**EN010122. Comments relating to the Non Material Change application for:
The Oakland's Farm Solar Park Order 2025 (SI 2025/739) & correction 2025 (SI 2025/1070)**

I shall comment upon each of the proposals based on the numbering appearing in the document: Non-Material Change Supporting Statement (EIA Addendum). Document Ref: EN010122/NMC/6.1

Works No. 4
Works No. 4a
Works No. 4b
Works No. 6
Works No. 8

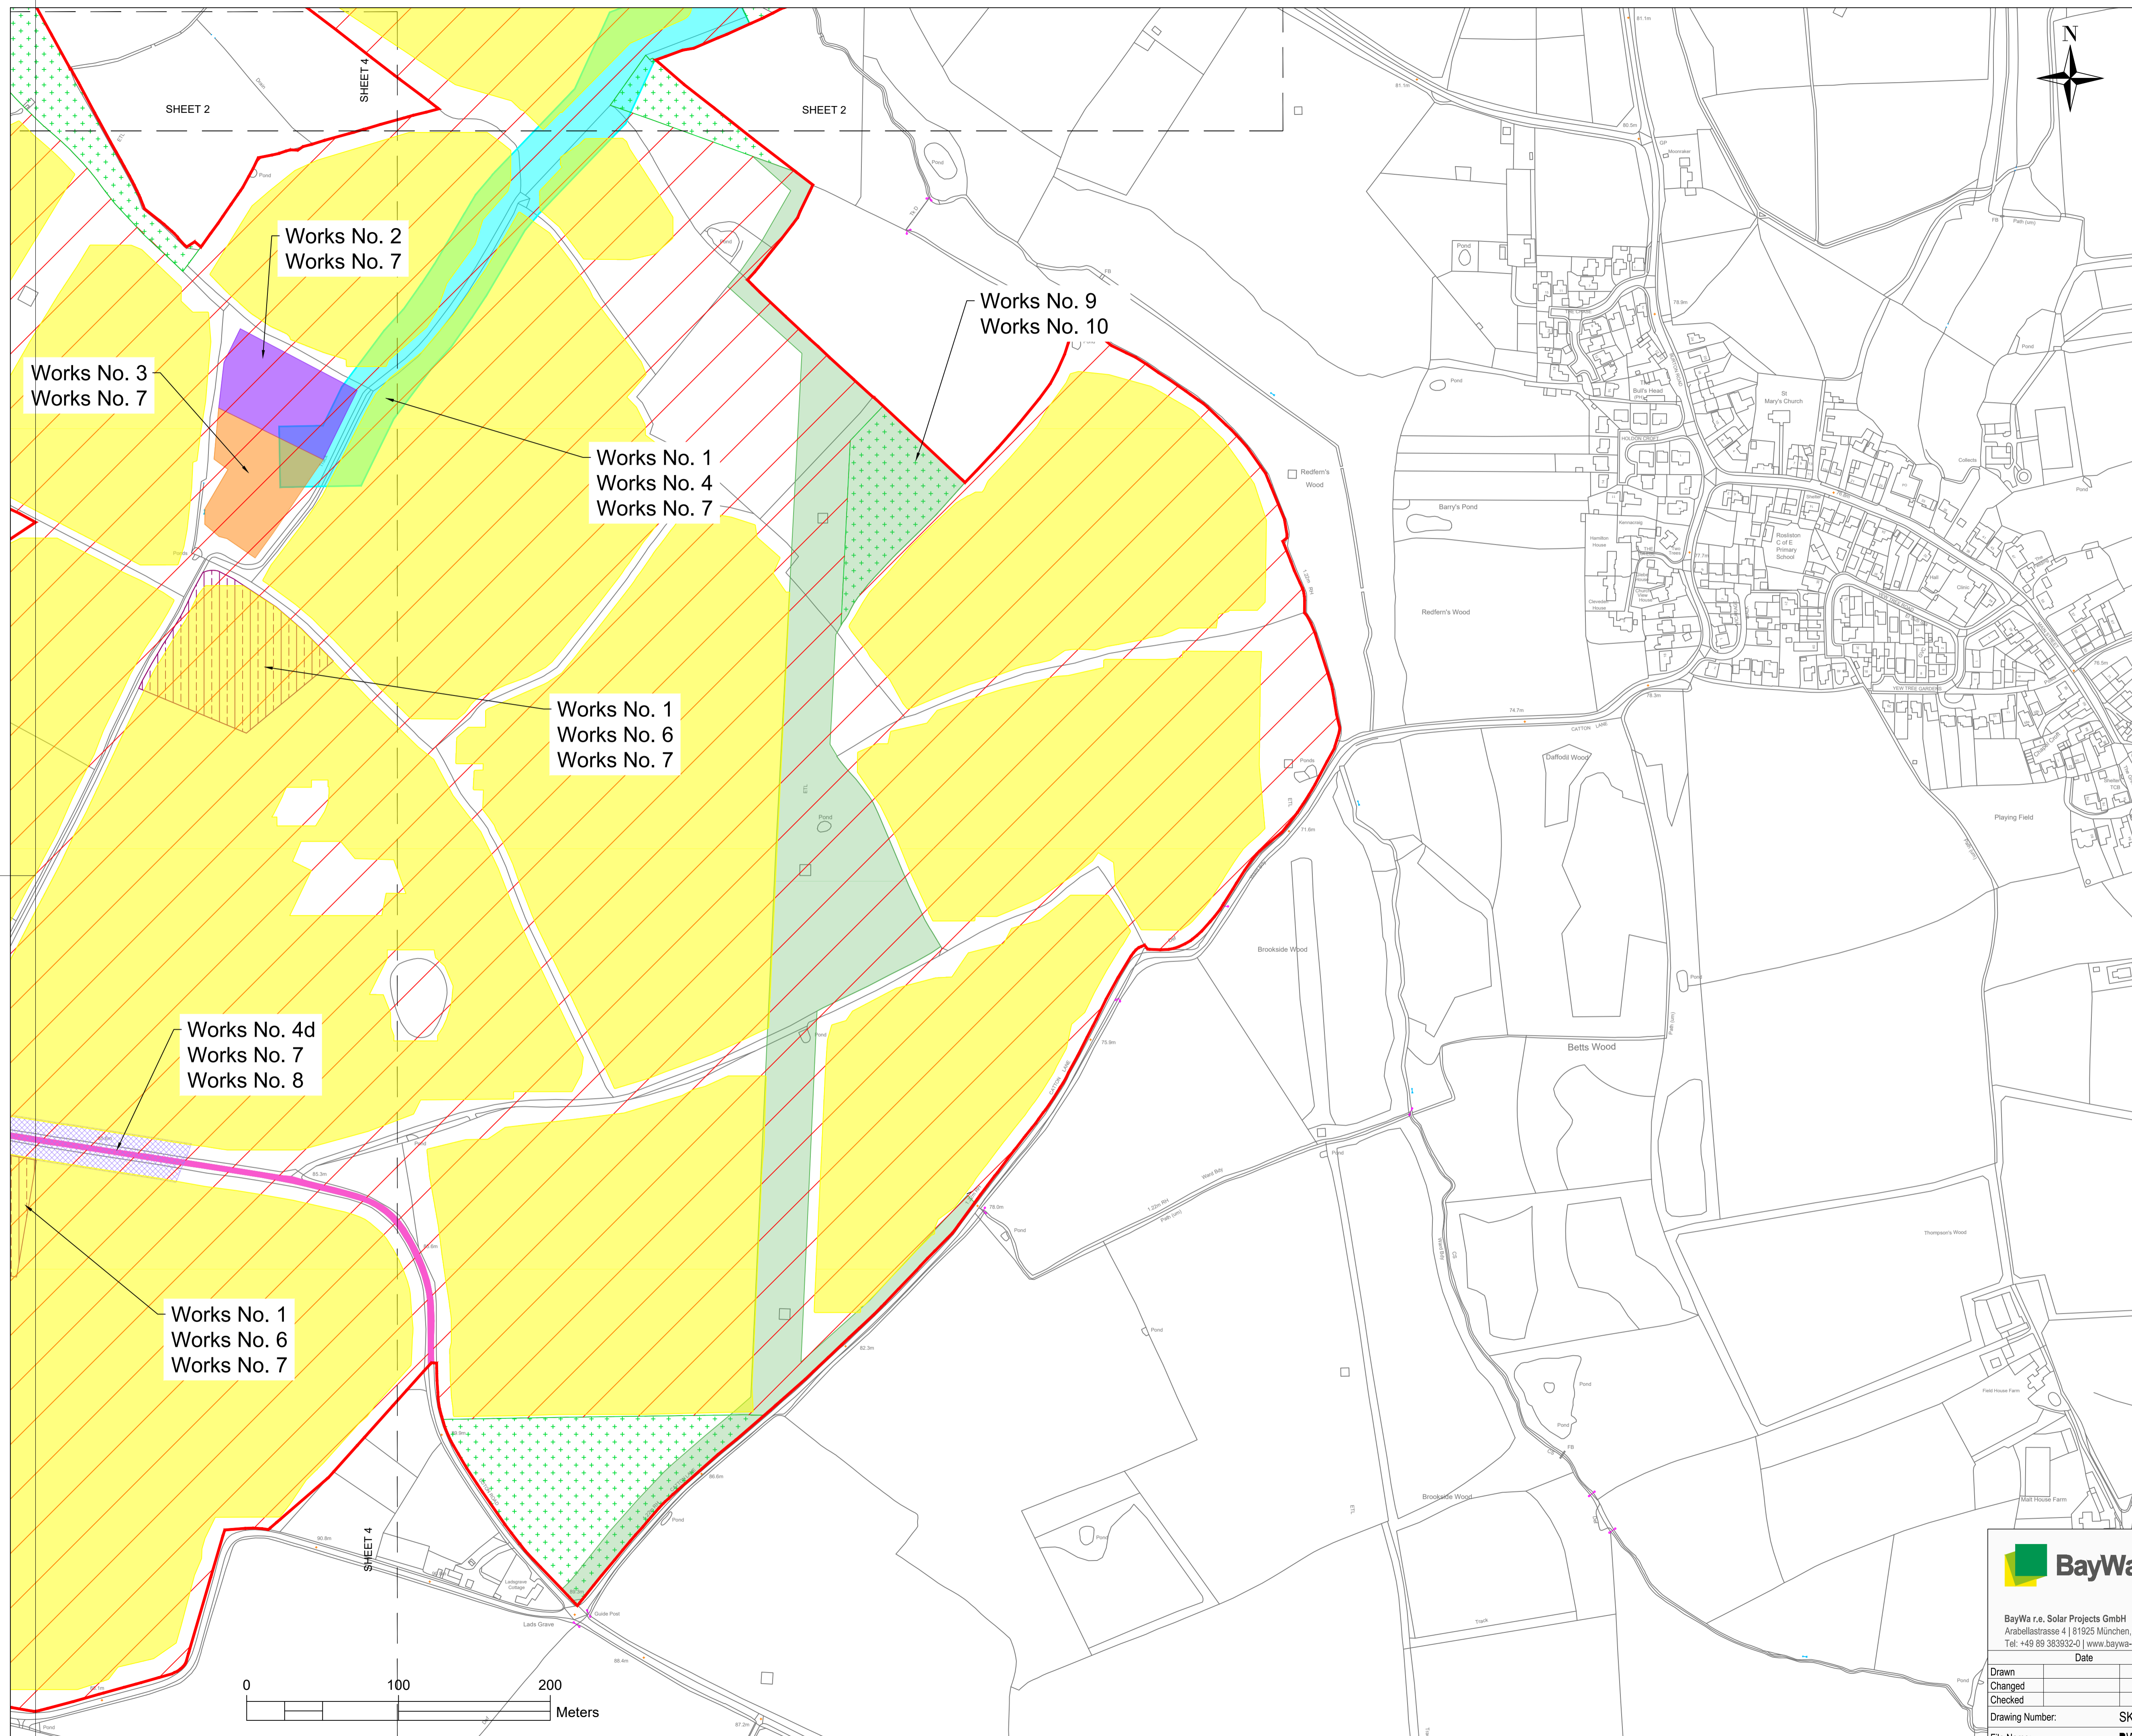
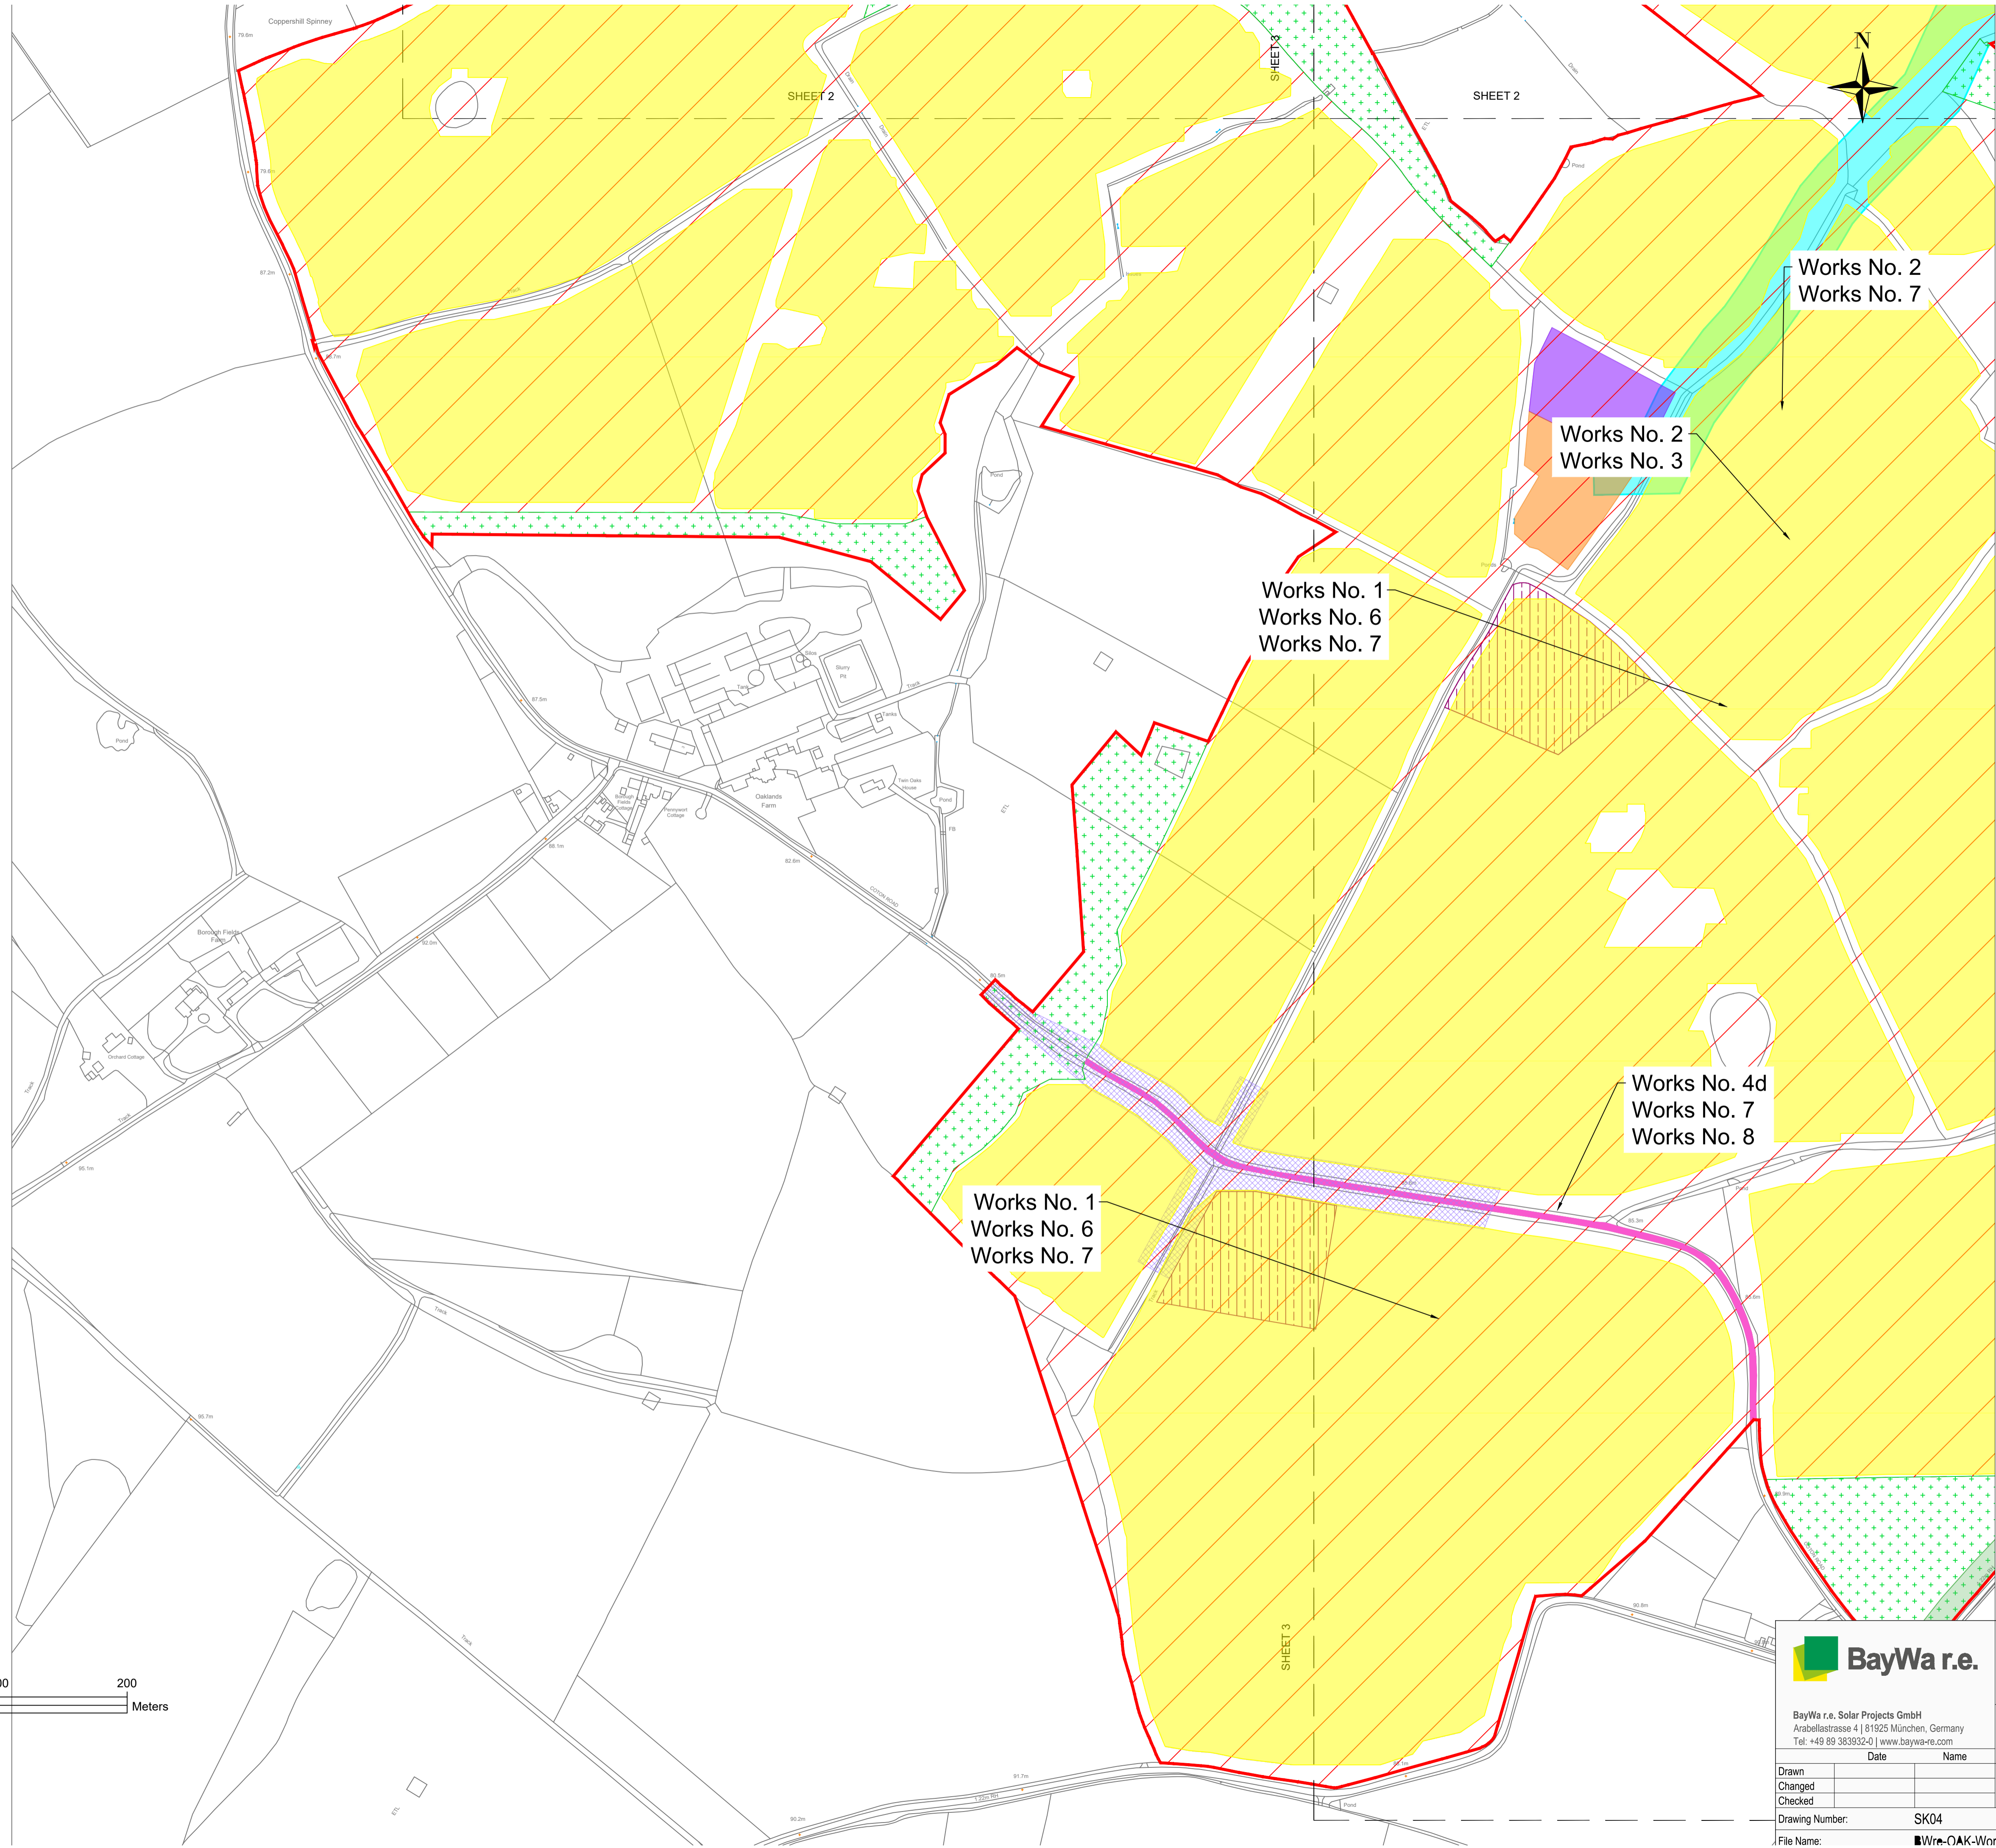
It seems from the diagrams of the extended solar panel areas that some hedgerows / trees / woodlands may be impacted with the panels encroaching closer than the 5m existing hedgerow boundary and/or the 15m tree root protection zone. Can this be checked and verified please?

If the solar panels now cover 3.4% more area than previously reviewed, how is this increase likely to impact on the drainage and subsequent flood management proposals?

One of the main areas where the solar panel coverage has increased borders Coton Road to the North West of Oakland's Farm. This road frequently floods in the dip by Copperhill Spinney and near the entrance to the farm / Chilled Hub (at the "slow" sign in the road). Can the applicant show that the increased run-off from the panels near the road do not exacerbate the flooding at the bottom of the hill?
